2 storey infill extension to front elevation & 1st
floor infill extension to rear elevation.

39 Conway Drive Pagham

Reference: PLANNING APPLICATION NO P/49/18/HH

*Proposed erection of two storey infill extension to front elevation and 1st floor infill
extension to rear elevation of 39 Conway Drive, Pagham, PO21 4XD by Mr M Hanley.*

FRONT ELEVATION PROPOSED 1:100

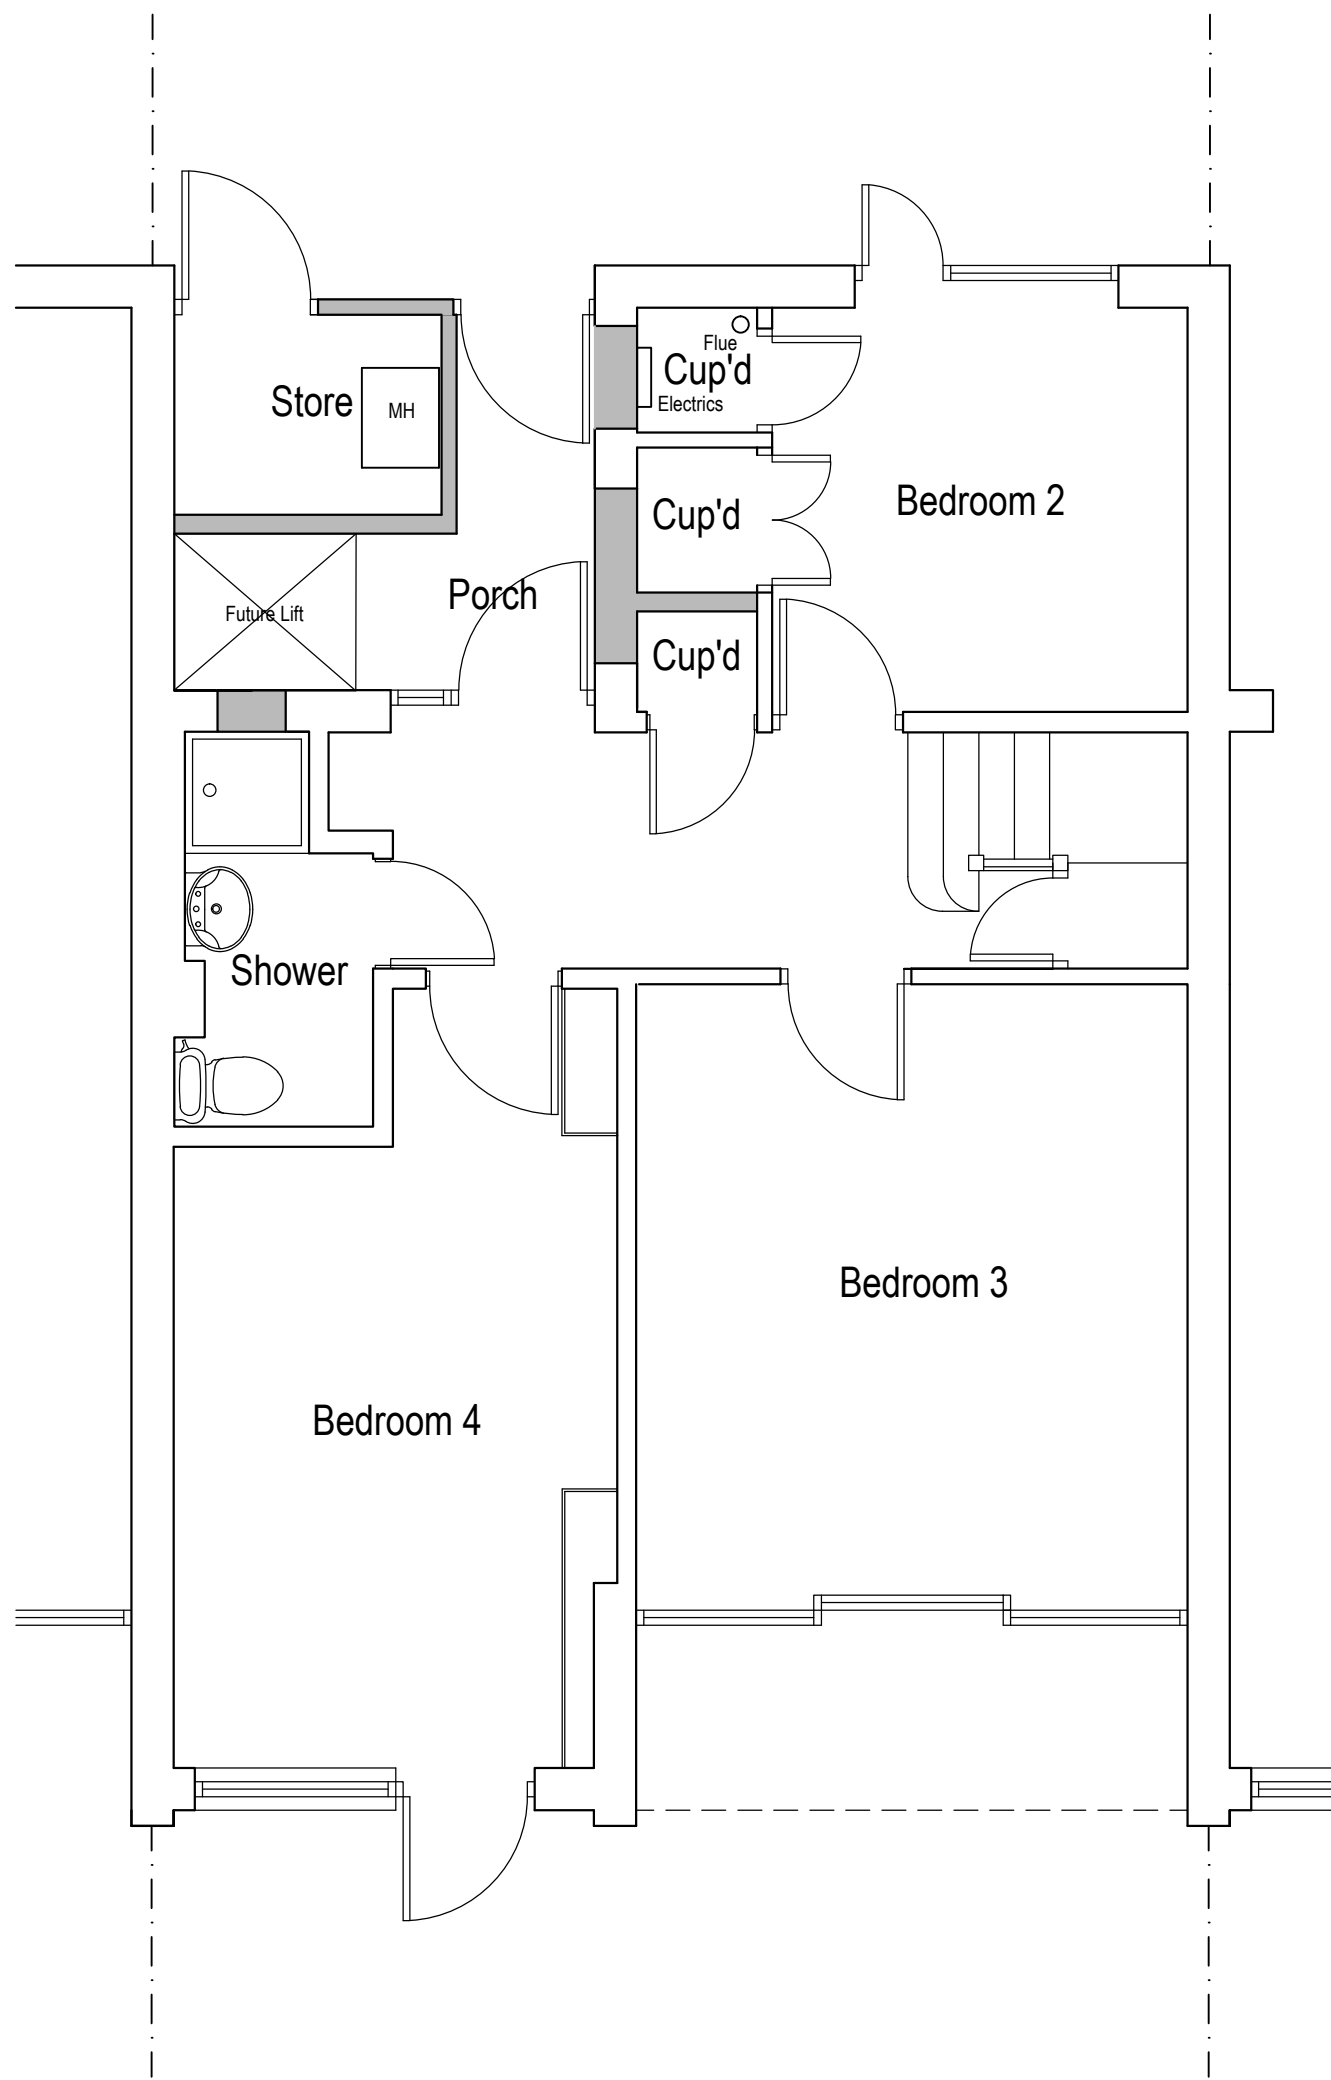
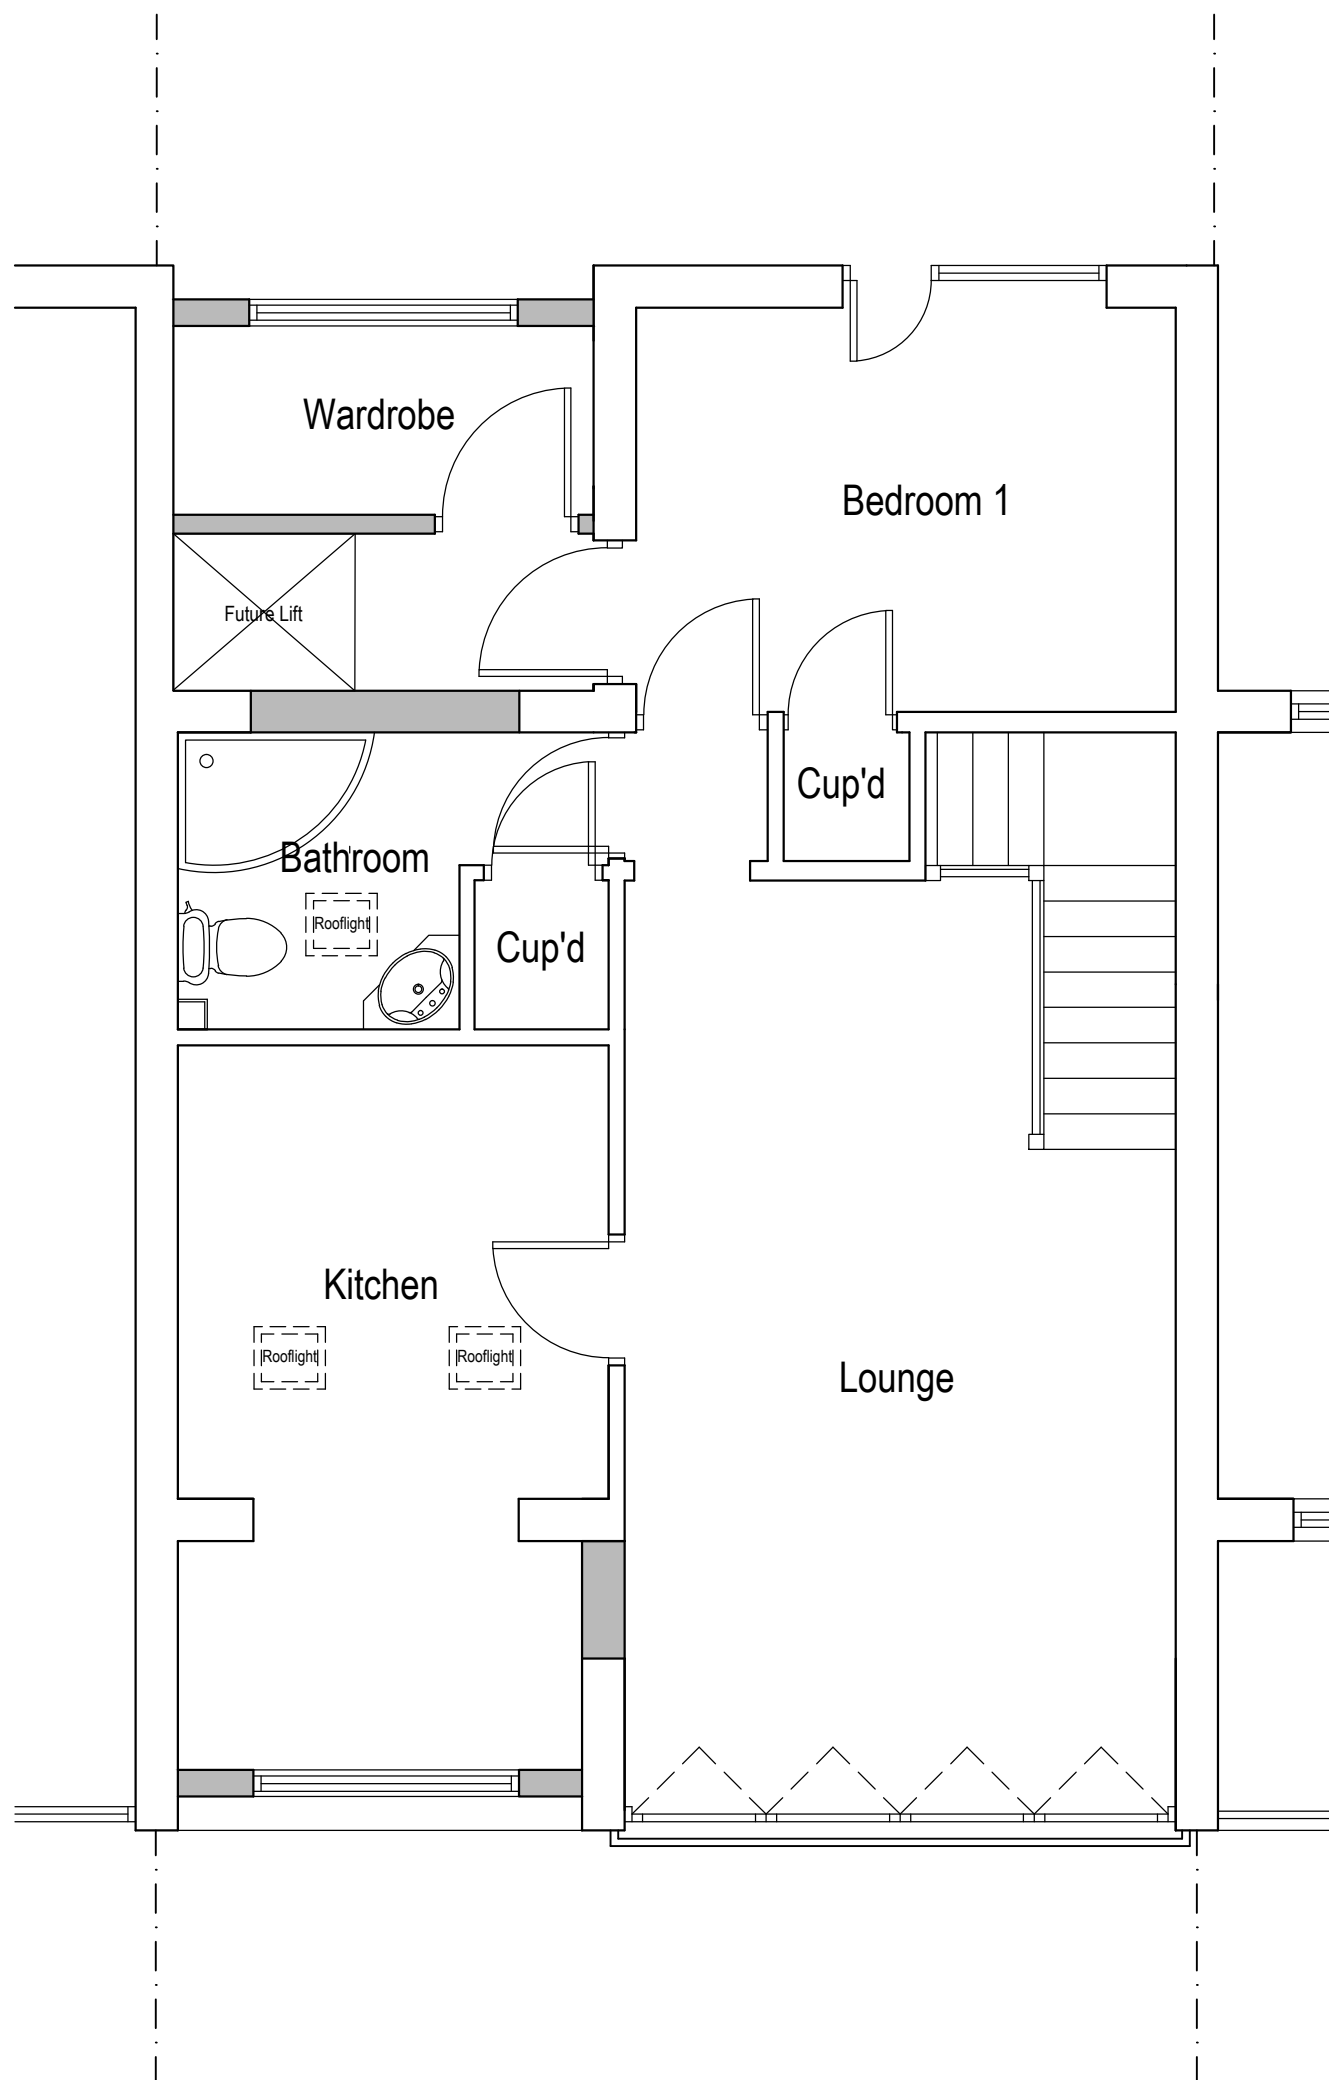
Conway Drive has currently two types of housing, single storey bungalows and two storey three bedroomed part terraced type houses. The house in question is sited within a row of nine of these two storey houses, four of which are identical in style built with yellow bricks to exterior, house number 39 is sited in the middle of these four. Infilling will ruin the character and have an adverse visual impact on this row of houses. When we moved into our house in 2014 our attention was drawn to the deeds where it clearly stated that there should be no boundary fences or walls erected as it would ruin the open appearance of the street. We would suggest that changing the appearance of number 39, and as a consequence house number 41, would totally change the look of the street and may also kick start a cascade effect and other street occupants may follow suit. All of the four houses, numbers 35-41, and indeed the other five red bricked versions numbers 25-33, have front rooms to both the ground and first floor elevations that are currently not connected to another property. As these houses are constructed internally using breeze blocks instead of bricks they are not well soundproofed and the two front facing rooms do give a little respite from neighbour noise audible in other areas of the property. And surely the proposed construction would impact negatively on the market value of house number 41 as it will become totally terraced and not part terraced as in its current state.

Similarly the proposed first floor infill extension to the rear of the property will change the appearance of the said houses. One other house in the row of nine has indeed closed in the current balcony area but its use is retained as a conservatory type area and not a living area ie; kitchen. This again will impact on number 41 and if approved could encourage other property owners to do the same thereby completely changing the appearance of these currently unique properties.
